PLANNING AMENDMENT

Application No: H11-0022-10-⁴³

Description: Residential Development comprising 79 dwellings and associated works (Outline H11-0845-07)

Amendment: Plot re-numbering and amendment to house type
(dwg. nos. 4093/B1, 4093/L1, 4093/E1 and 4093/A18)

Plans & Elevations
Plots 1, 2, 66, & 71 - 73

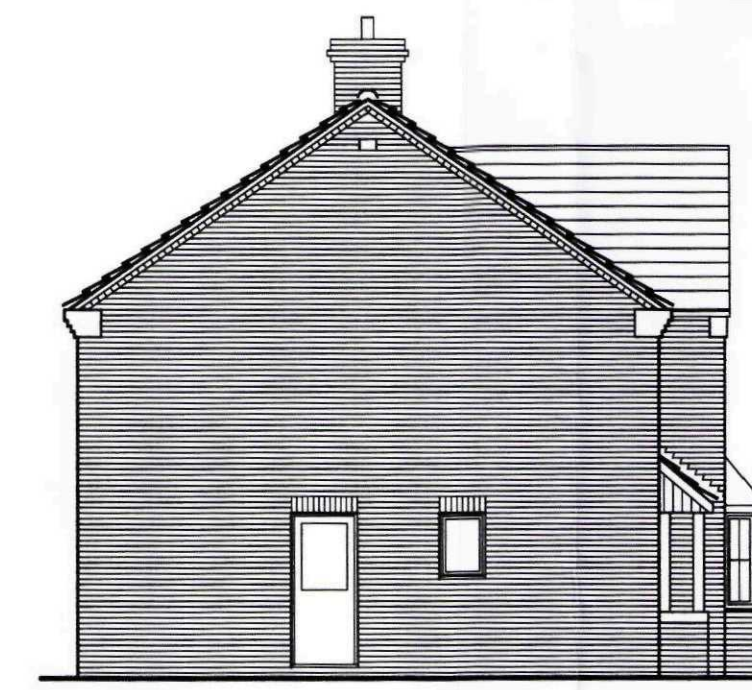
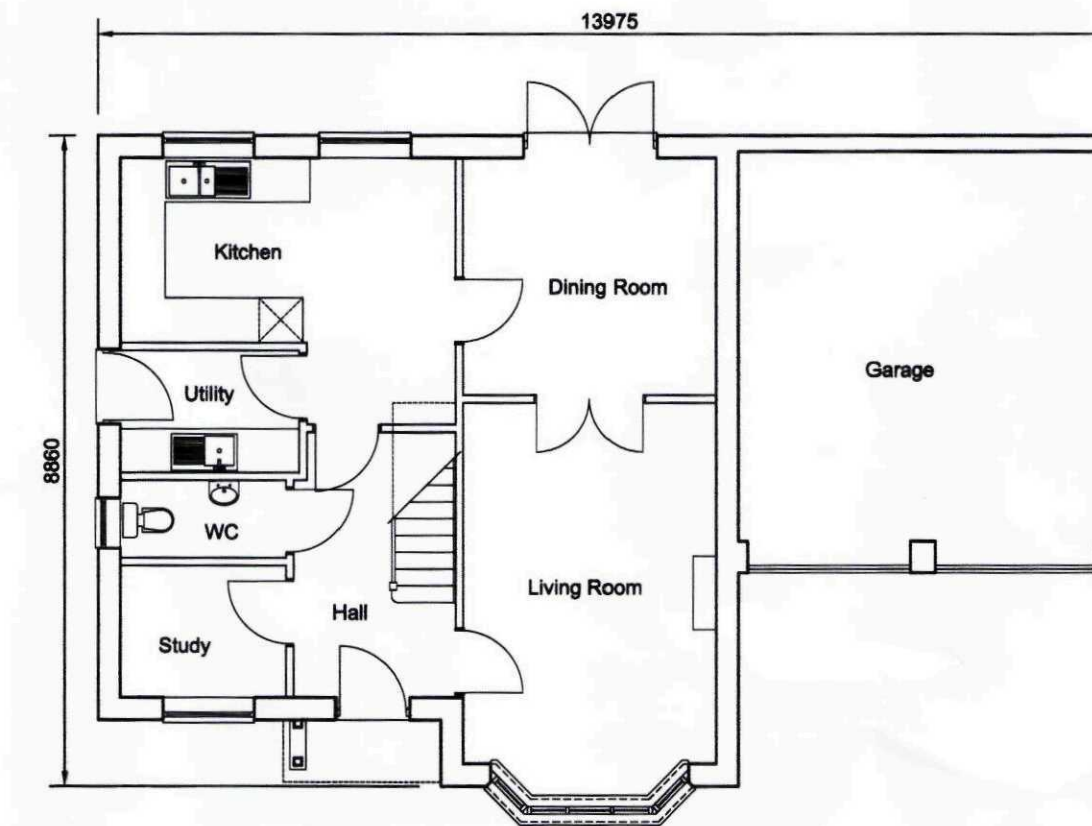
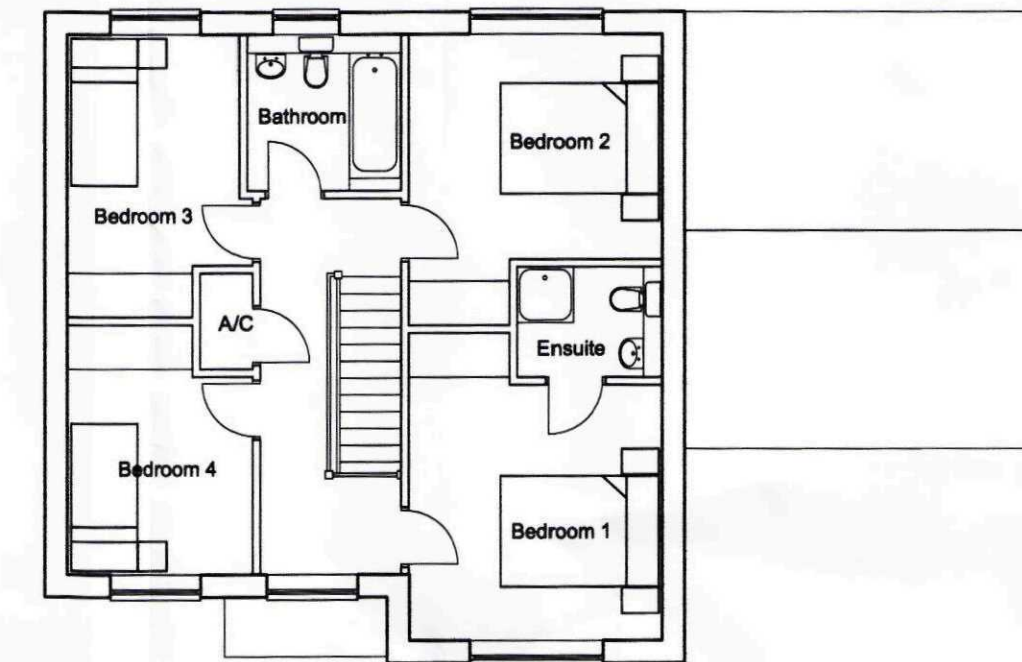
Further to our discussion in relation to the above I enclose for your attention some revised drawings indicating the amendments to plot 1 4093/B1, details as to plot 79 as per drawing no. 4093/L1 and drawing no. 4093/E1 which corrects some incorrect numbering arrangements on the previous drawing.
